A Planning Application by
COMPLETE PLANT HIRE LIMITED

In respect of
**12 Southfields,
WELWYN GARDEN CITY**

Technical Note – Survey Summary

August 2021

SWEPT PATH ANALYSIS OF
 A 26t RIGID VEHICLE

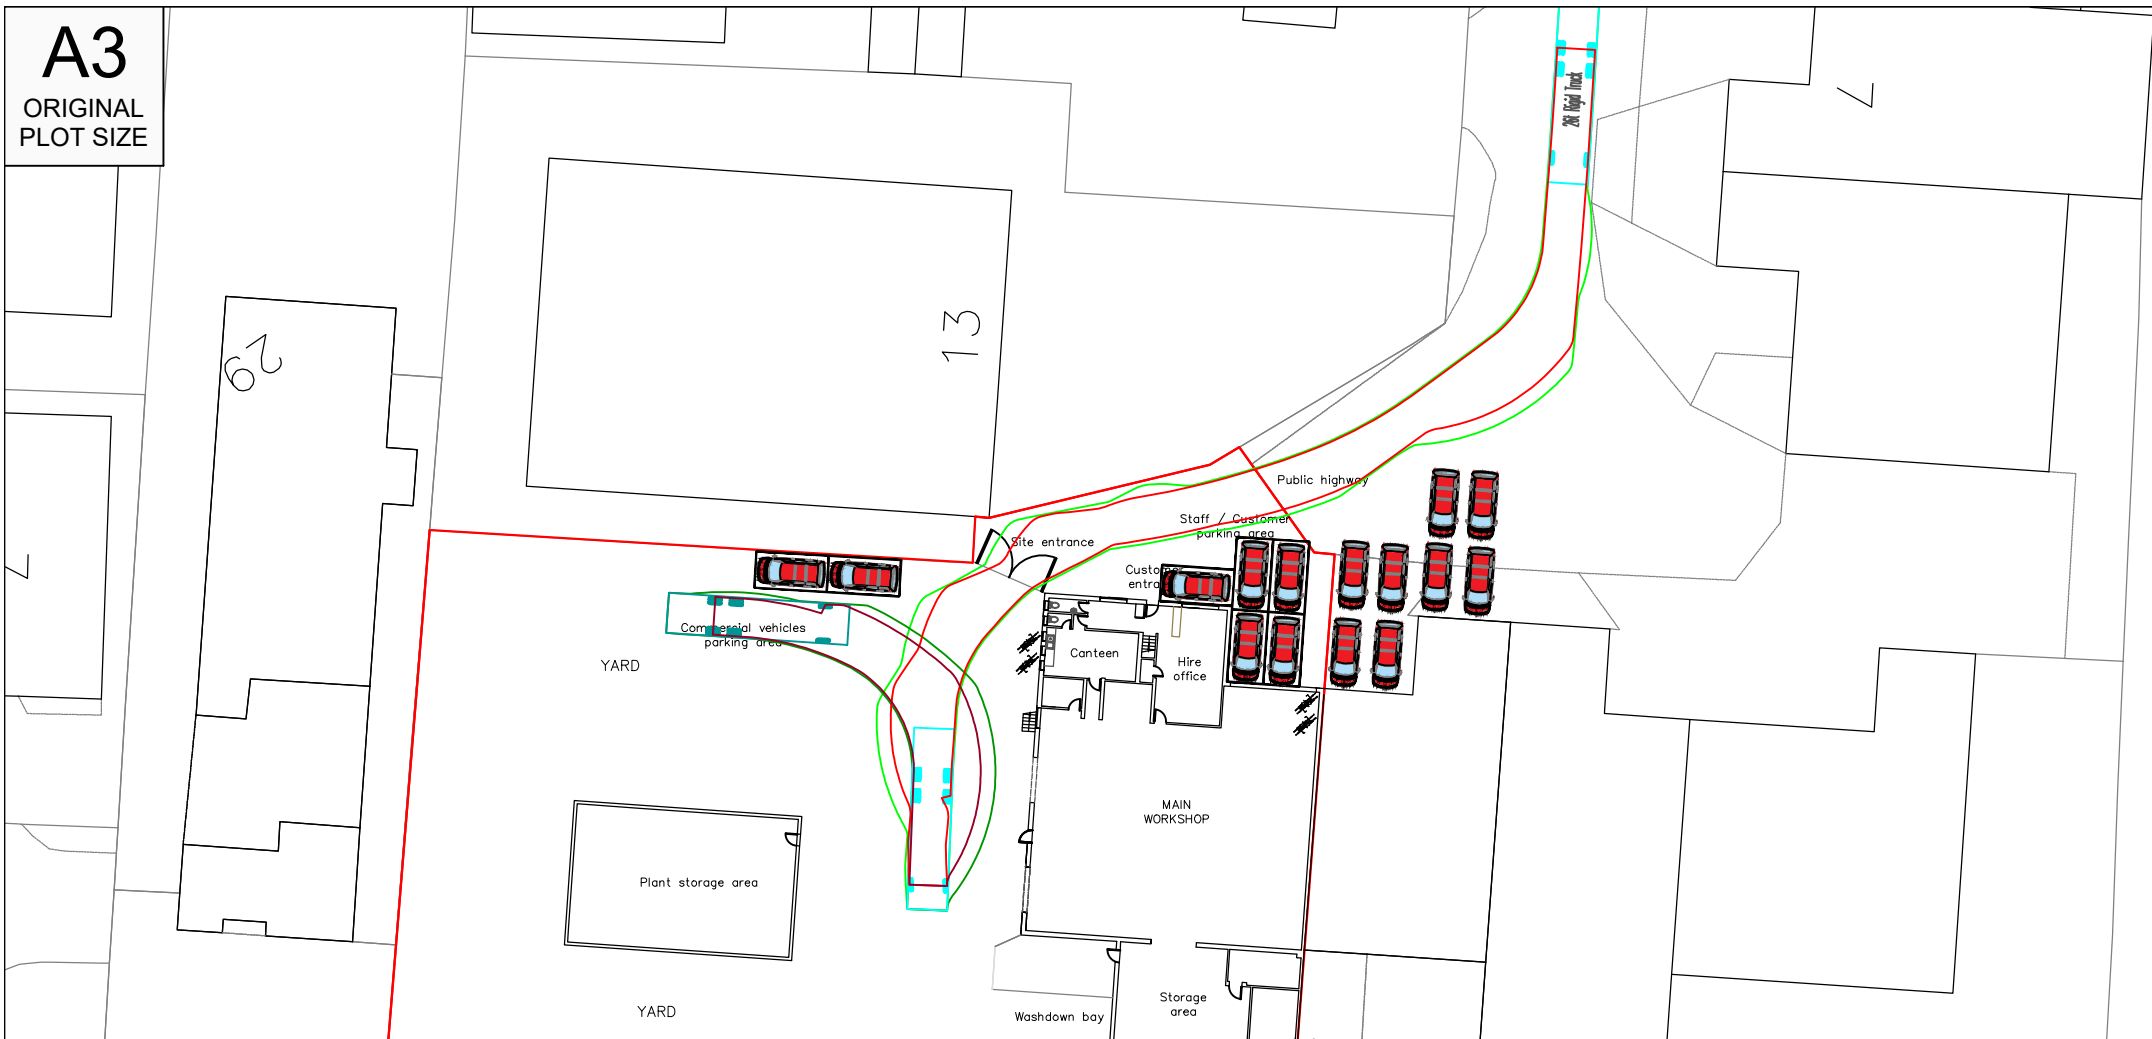
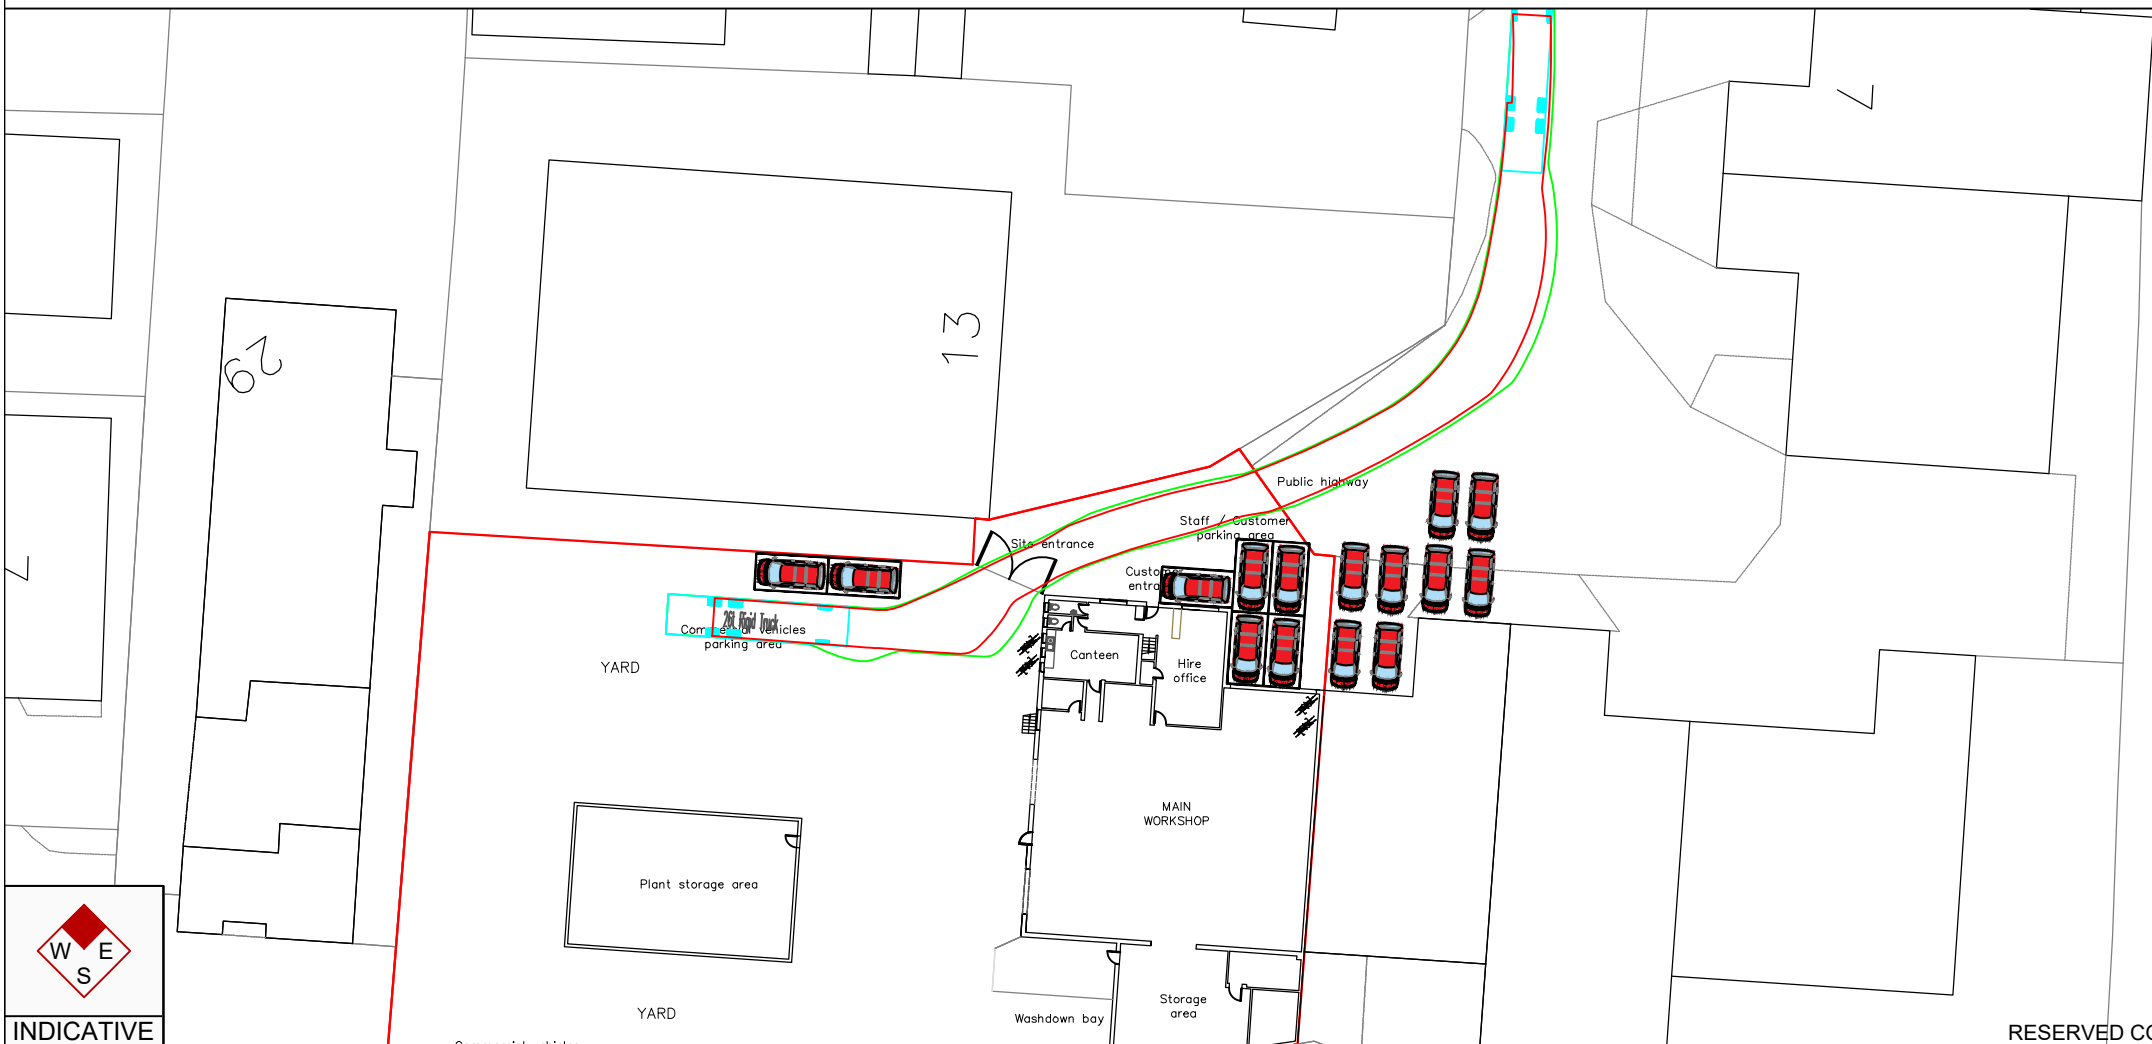
“The Highway Authority are concerned that the Transport Technical Note contained only limited details of the types of vehicle that access the site and therefore the swept path shown in Drawing No. SP01 may not representative of the largest vehicle that will commonly use the site (i.e. lengths of low loaders and articulated vehicles). Without these details there is a highway safety risk that large vehicles may reverse long distances on the public highway.”

- 3 x Box Vans - 6.5m x 2.1m;
- 1 x 26 tonne rigid trucks - 12m x 2.55m; and
- 2 x pick-up trucks - 6.6m x 2.1m.

2.10 A swept path analysis of a 26 tonne vehicle has been undertaken and is contained within **Appendix C**. As can be seen, the vehicle can enter and exit the site in forward gear. This manoeuvre can be seen in the CCTV survey.
